From:
Sent: 05 August 2026 05:51
To: DC Admin
Subject: Final comment - Planning application 2026/91900 – Supplementary objection regarding access to No. 68
Attachments: IMG_20250901_080654.jpg

Existing access
to no.68 to
be maintained

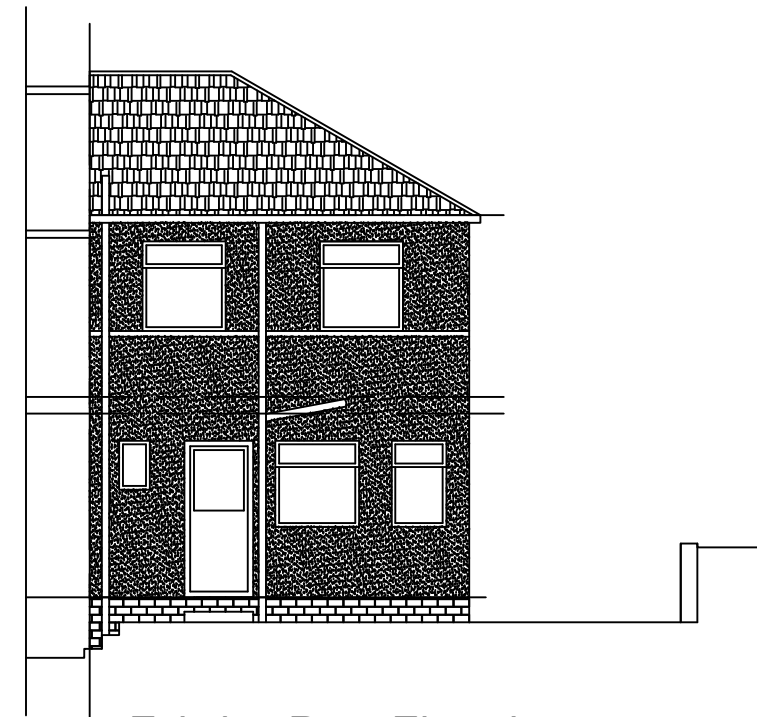
The drawings measure a 70 cm gap from a straight boundary line, but this does not represent the actual usable width at my property. The real access route includes a recess, a level change, steps, a pipe, brickwork and a 90-degree turn, none of which are shown on the plans. These features significantly reduce the usable width at ground level, which is where access is required for maintenance and moving items.

Proposed Ground Floor Plan

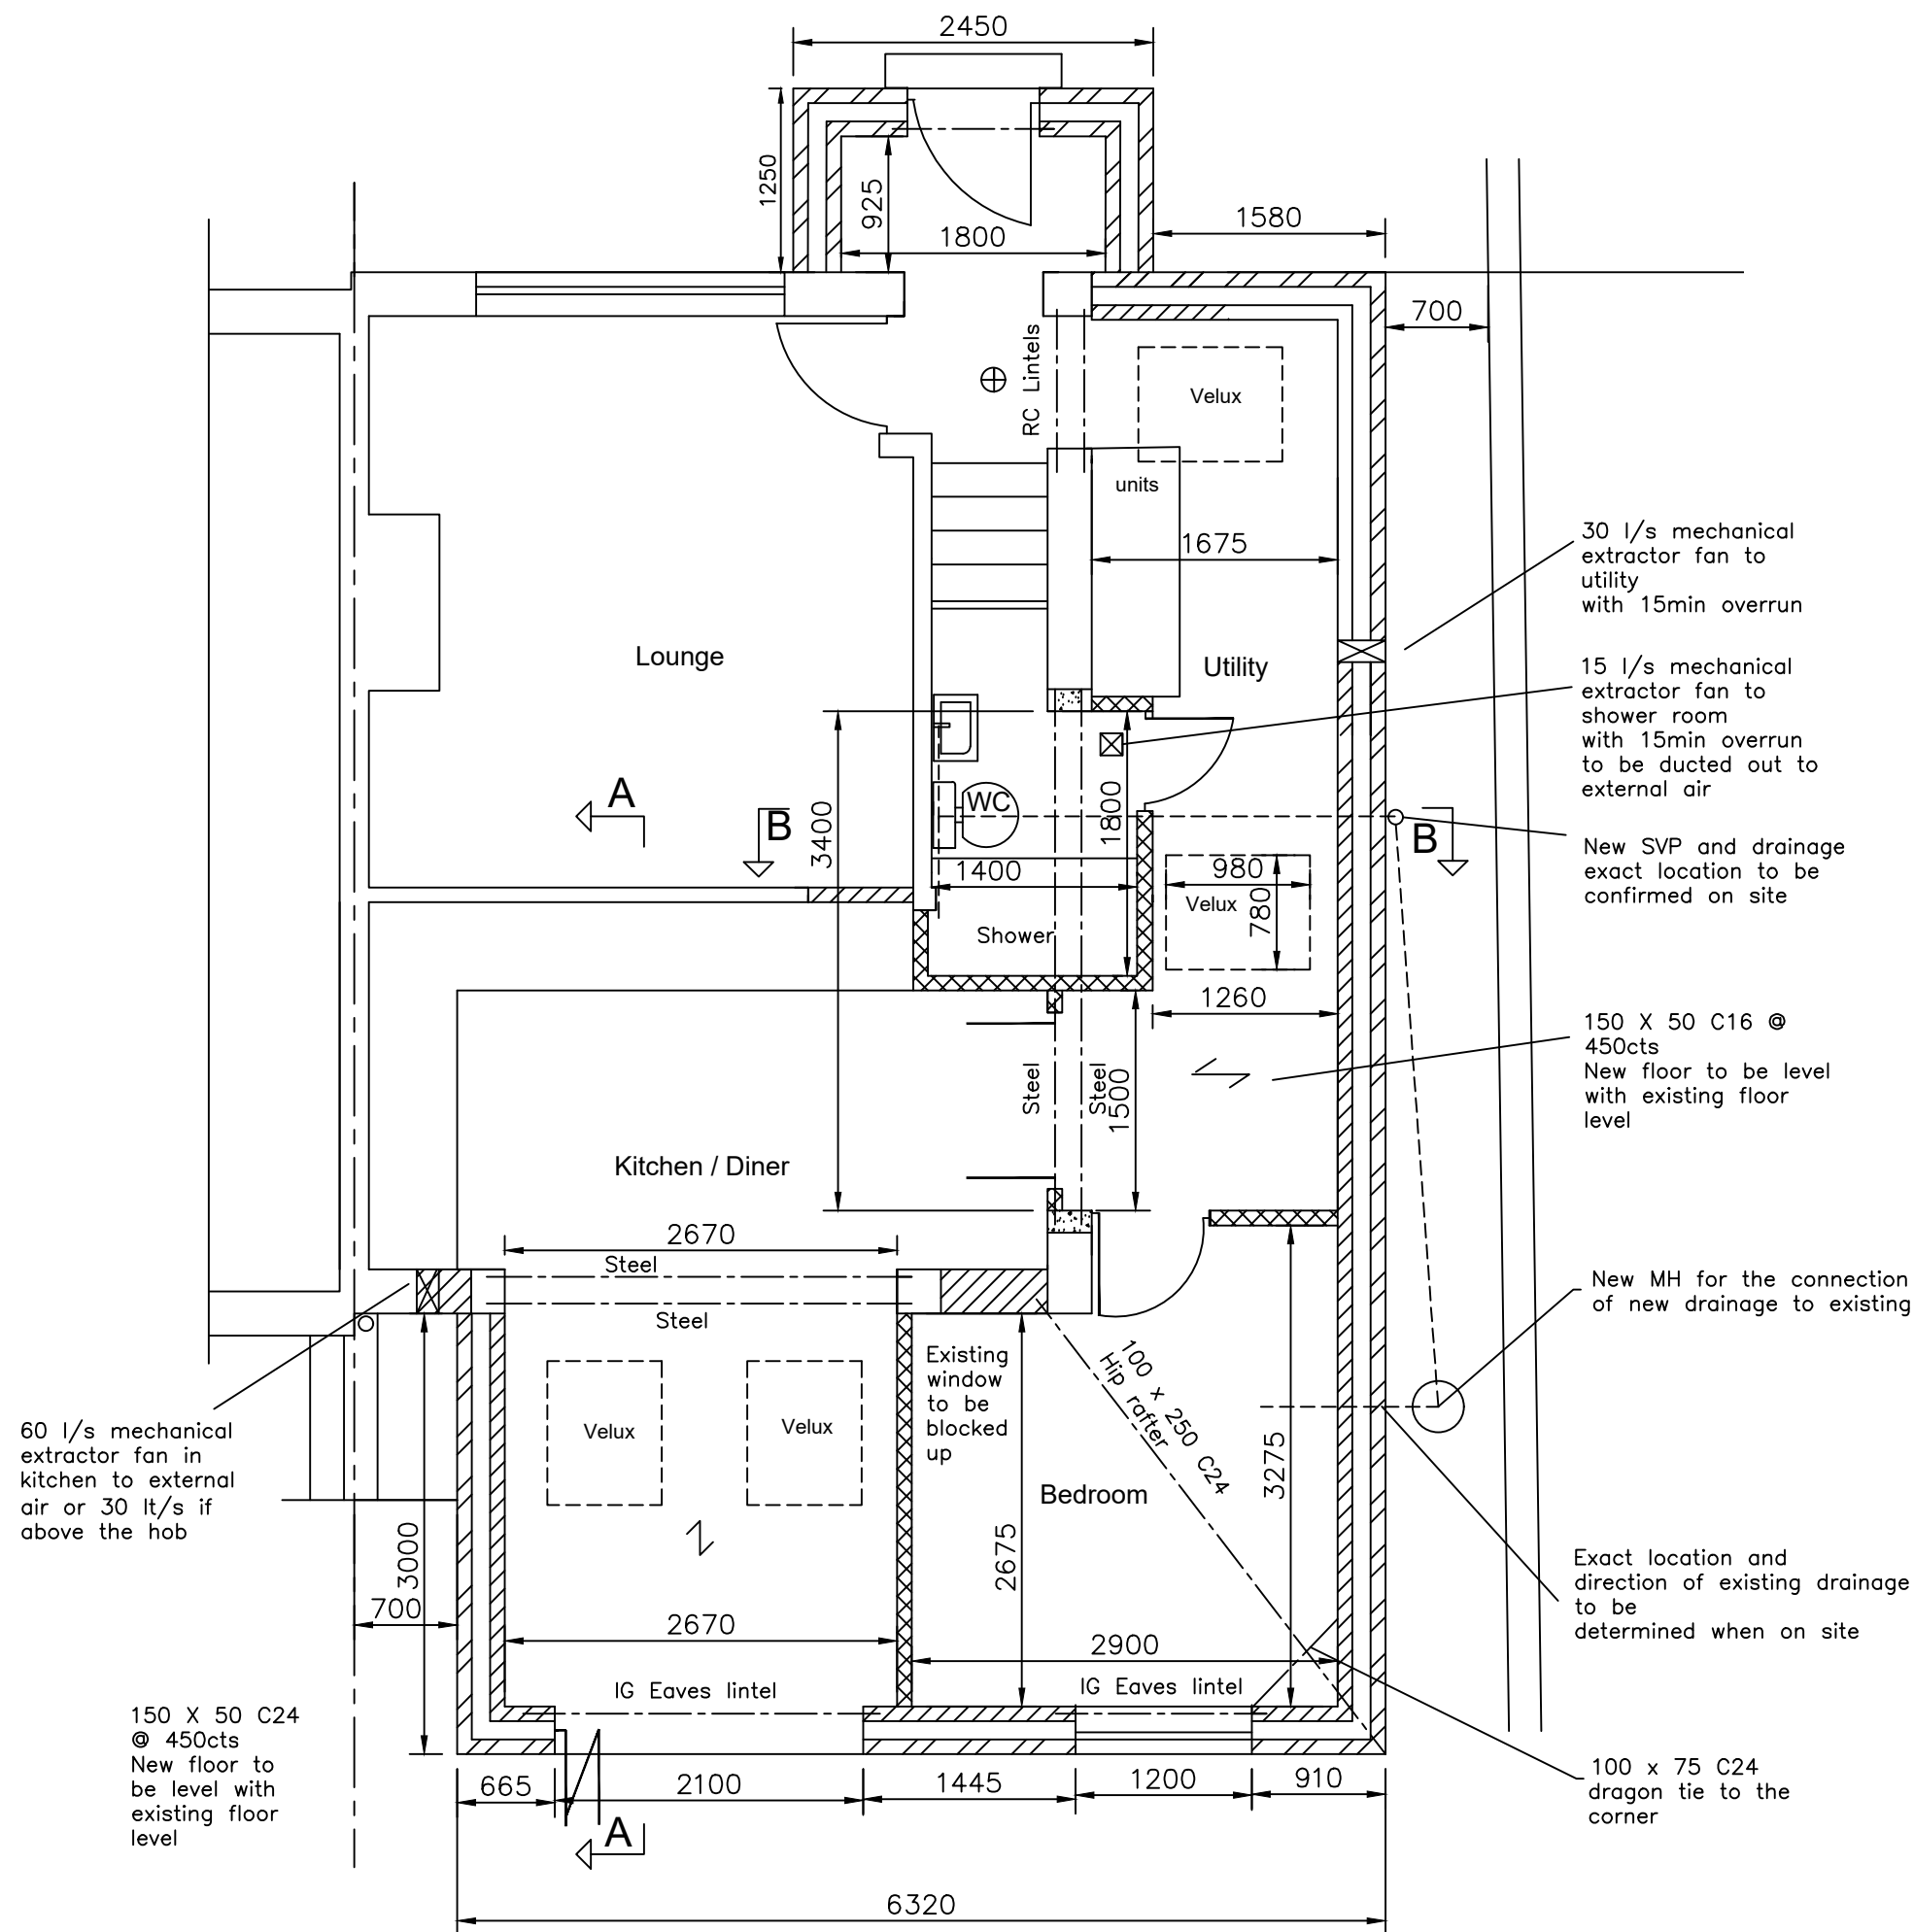
The plans also omit drainage details along this side passage, and they show a mechanical extractor fan positioned directly beside my only rear access point. Both issues have a direct effect on how I am able to use and maintain my property.

Because of these omissions, the 70 cm measurement on the drawing does not reflect the actual pinch-point, and I would be grateful if this could be considered when assessing the proposal.
